WEST SUSSEX COUNTY COUNCIL CONSULTATION

TO:	Arun District Council - FAO: Simon Davis
FROM:	WSCC - Highways Authority
DATE:	16 November 2020
LOCATION:	Land to West of Hook Lane, Westergate, PO20 3TE
SUBJECT:	AL/79/20/OUT Outline planning application with some matters reserved (Layout, Scale, Appearance and Landscaping are to be determined as reserved matters) for the construction of 10 No. dwellings & the creation of a new vehicular & pedestrian access on to Hook Lane. This application is a Departure from the Development Plan.
SITE VISIT:	16/11/2020
RECOMMENDATION:	More Information

West Sussex County Council, in its capacity as the Local Highway Authority (LHA), have been consulted on outline application with matters of access sought for 10 x dwellings (2 x 2-bed, 3 x 3-bed, 5 x 4-bed) on land west of Hook Lane.

ARUN DISTRICT COUNCIL AL/79/20/OUT

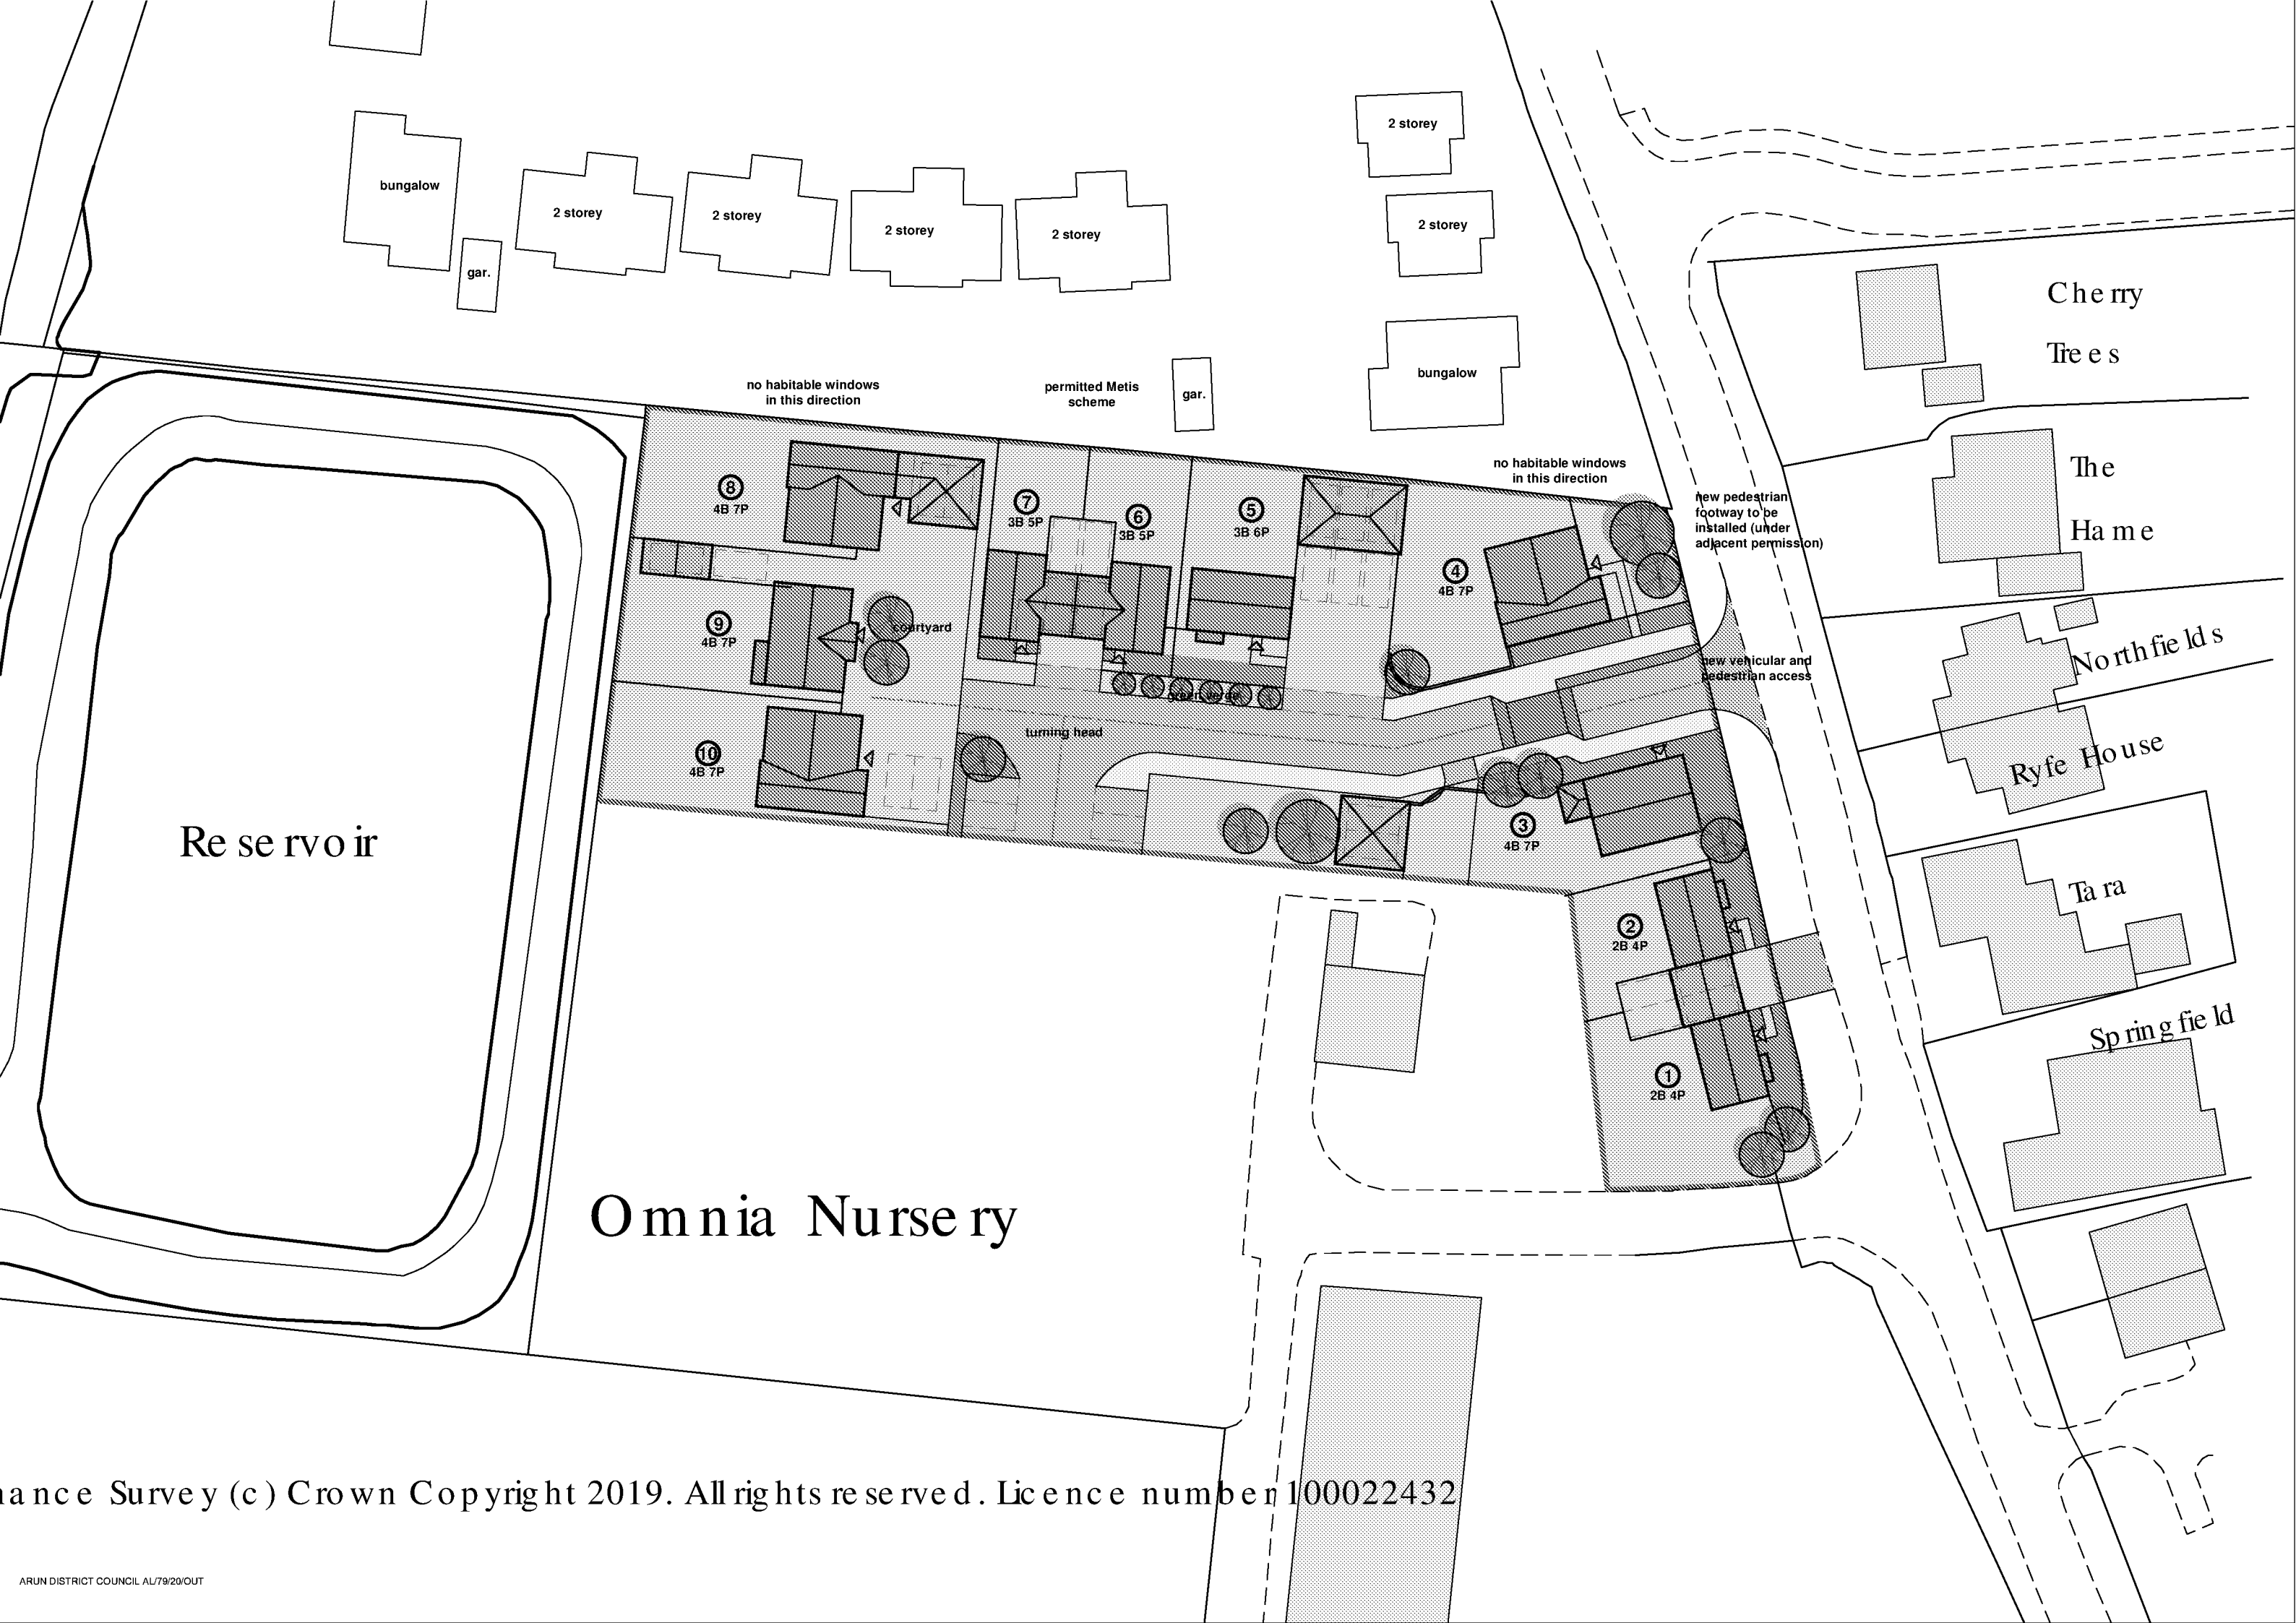
An ATC survey was undertaken in vicinity of the site access which recorded 85th percentile wet weather speeds of 28mph southbound and 28.8mph northbound. (30.4mph southbound and 30.2mph northbound - reduced by 2.4mph for wet weather as per para. 7.5.2 Manual for Streets). The wet weather speeds would require visibility splays of 39m north and 40m south. The TS details splays of 2.4m by 36.5m north and 38.1m south from the main site access. The splays demonstrated are short by 2.5m north and 1.9m south. No splays have been

shown for the new crossover to plots 1 & 2. From an inspection of WSCC highway boundary mapping it appears that a greater splay may be achievable using land within the red edge of the site and public highway. The applicant is advised to provide amended plans showing *maximum achievable* visibility splays from both the main site access and new crossover to plots 1 & 2.

- Demonstrate maximum achievable visibility splays from both new bellmouth access and new crossover.
- Site access plan to include extent of footway currently in the vicinity and show extent of footway tie-in proposed, along with clarification of west-east crossing points proposed across Hook Lane.
- Stage 1 RSA and accompanying Designers Response as per GG119 format (table F4 & F5).

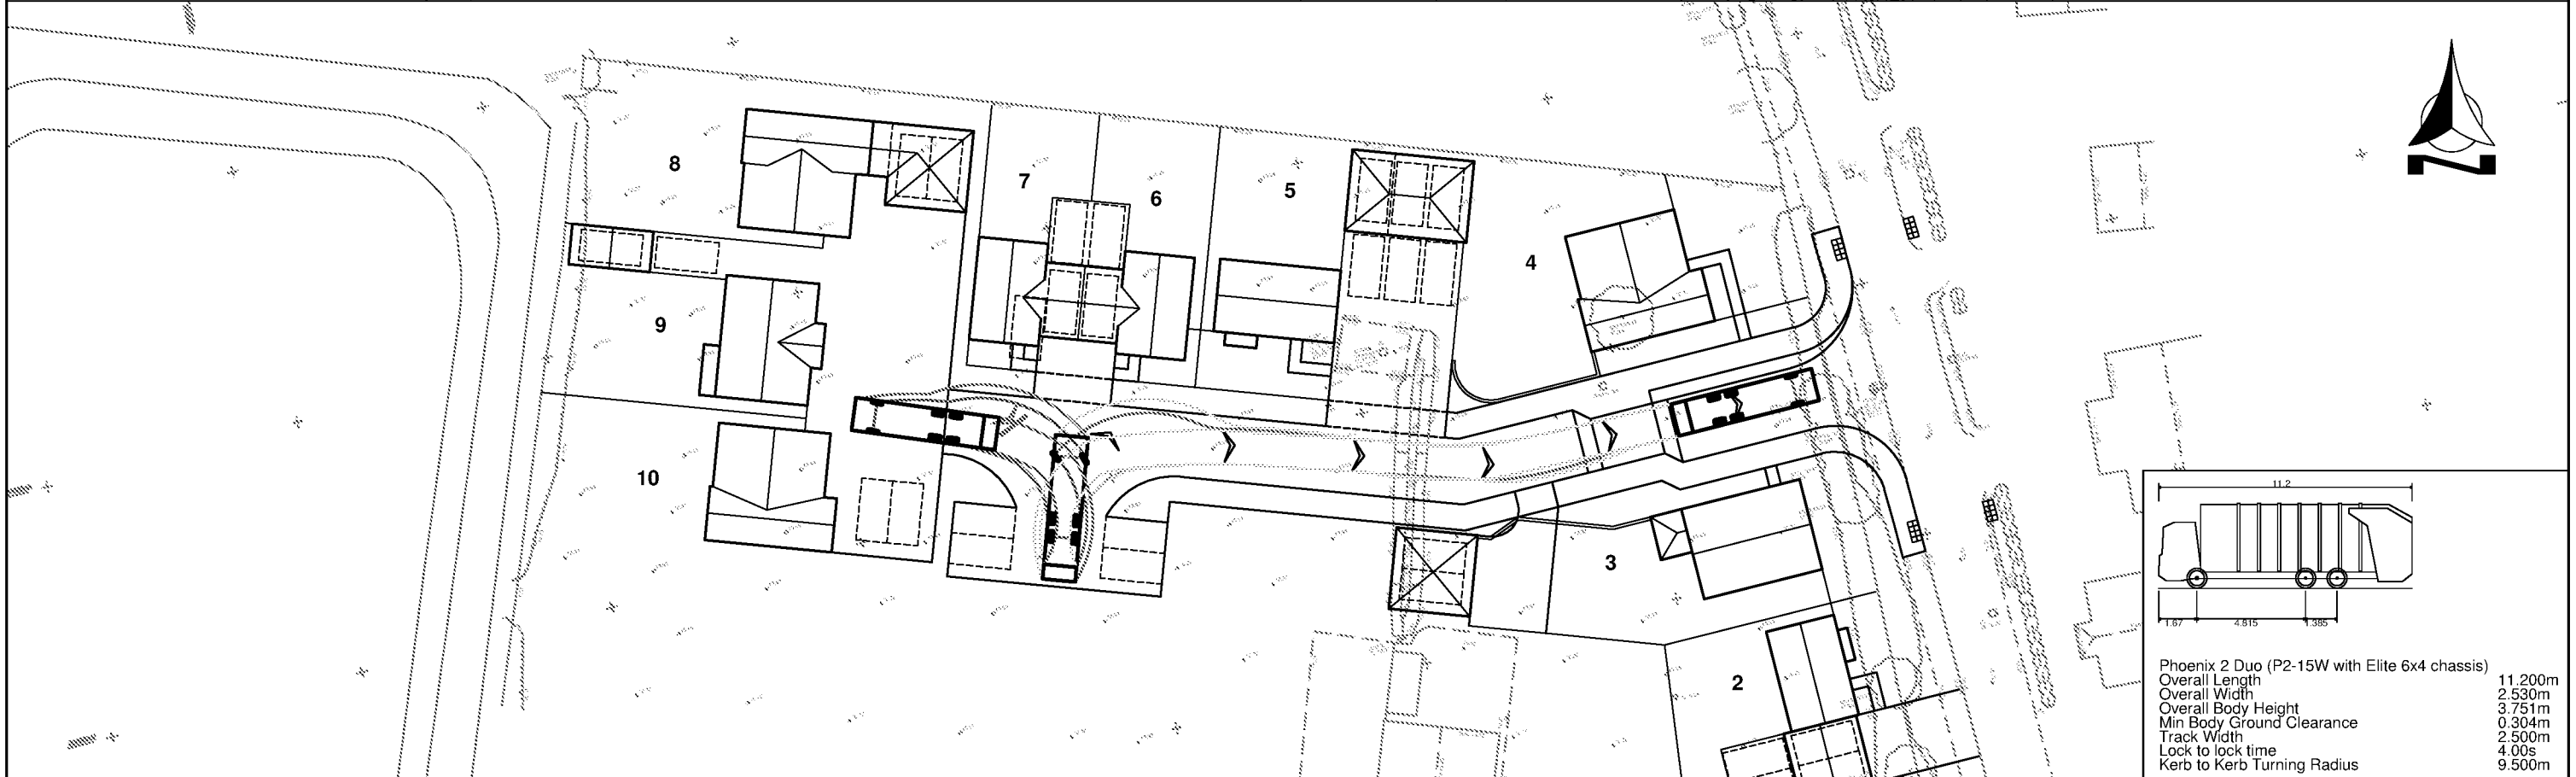
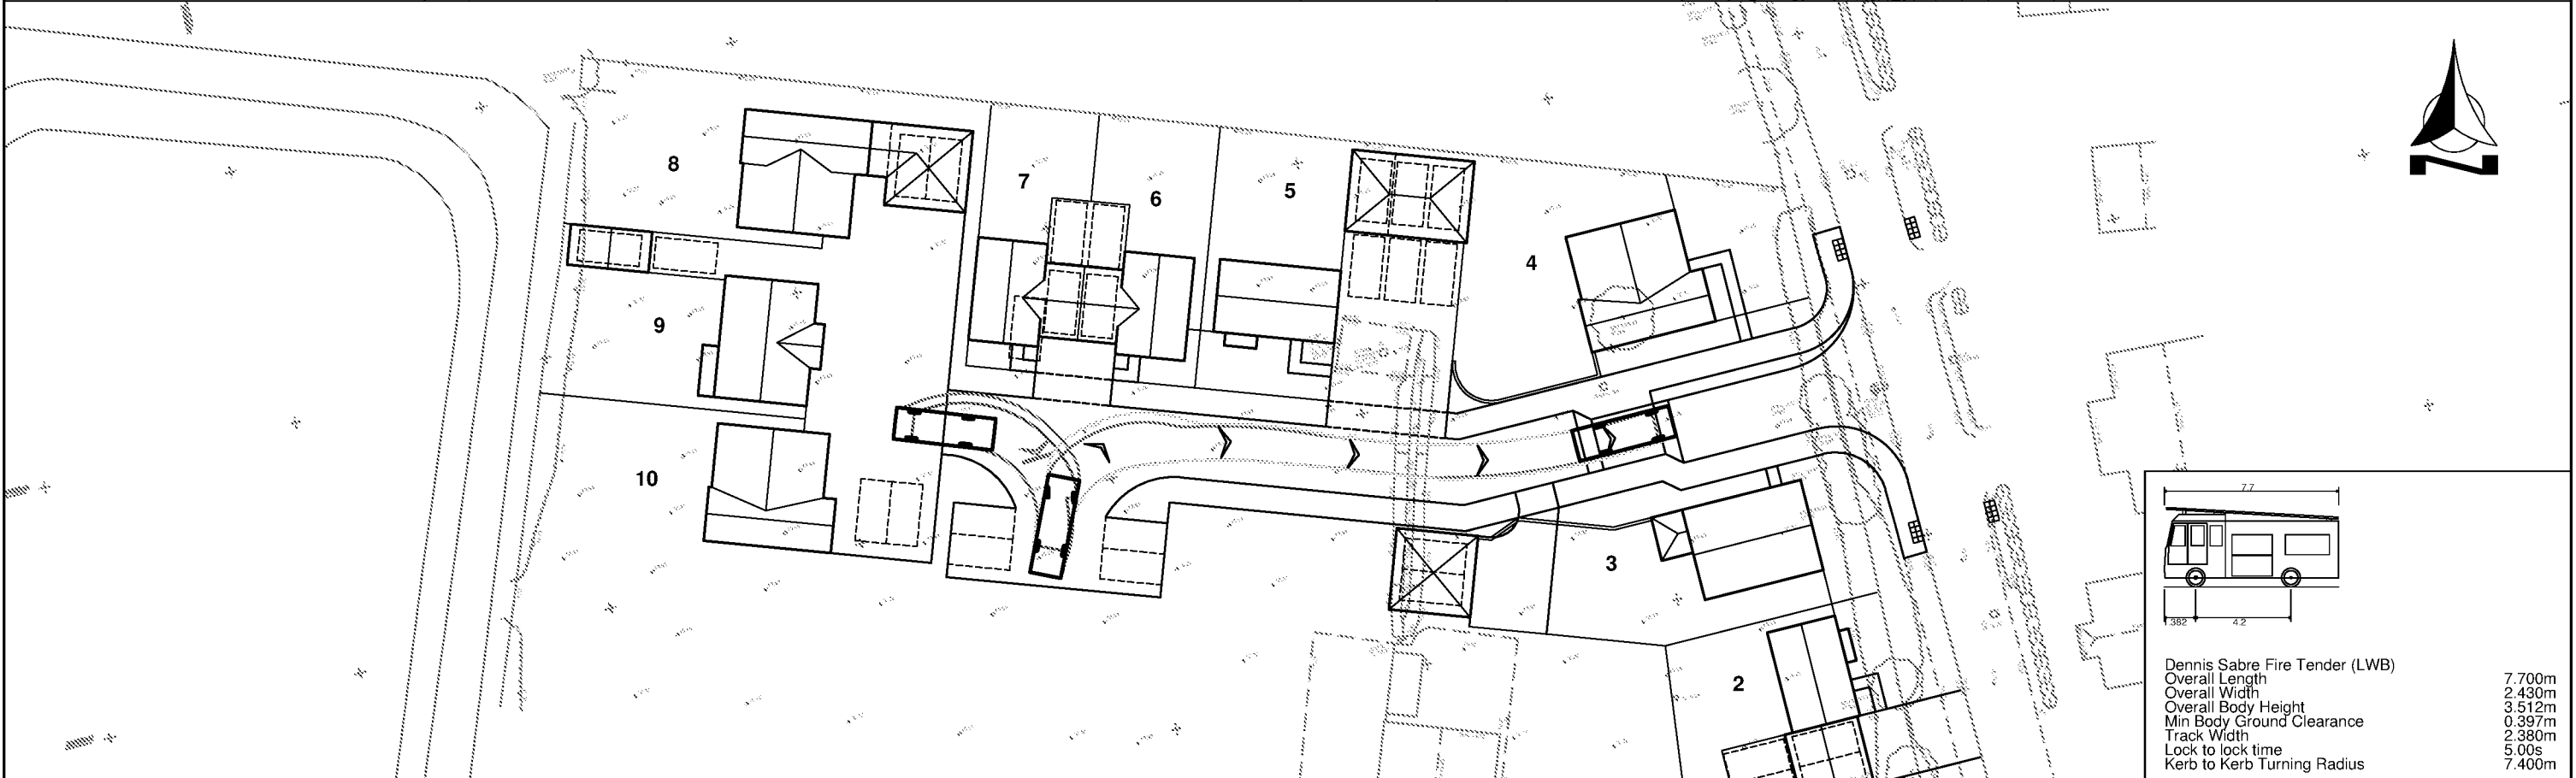
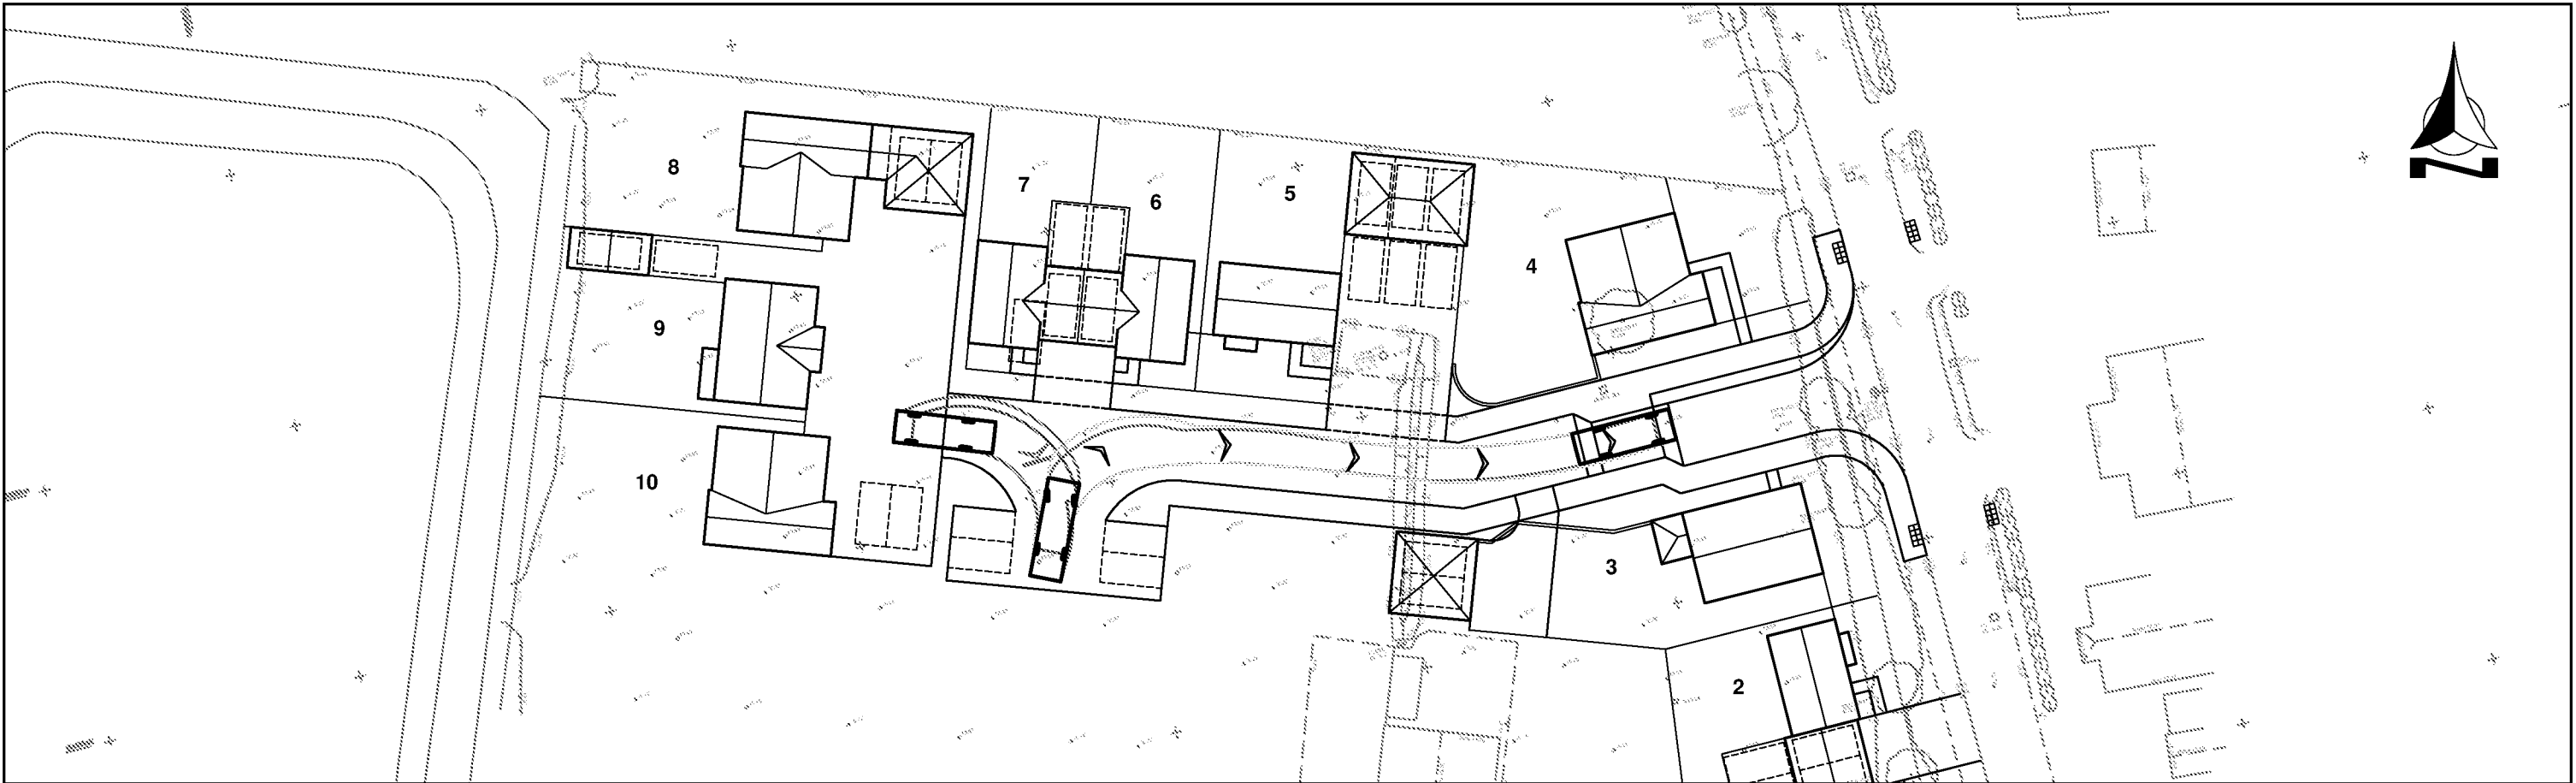
Swept path tracking diagrams have been provided for the main site access which show a fire tender and a refuse collection vehicle can access and turn within the site, in order to exit in a forward gear.
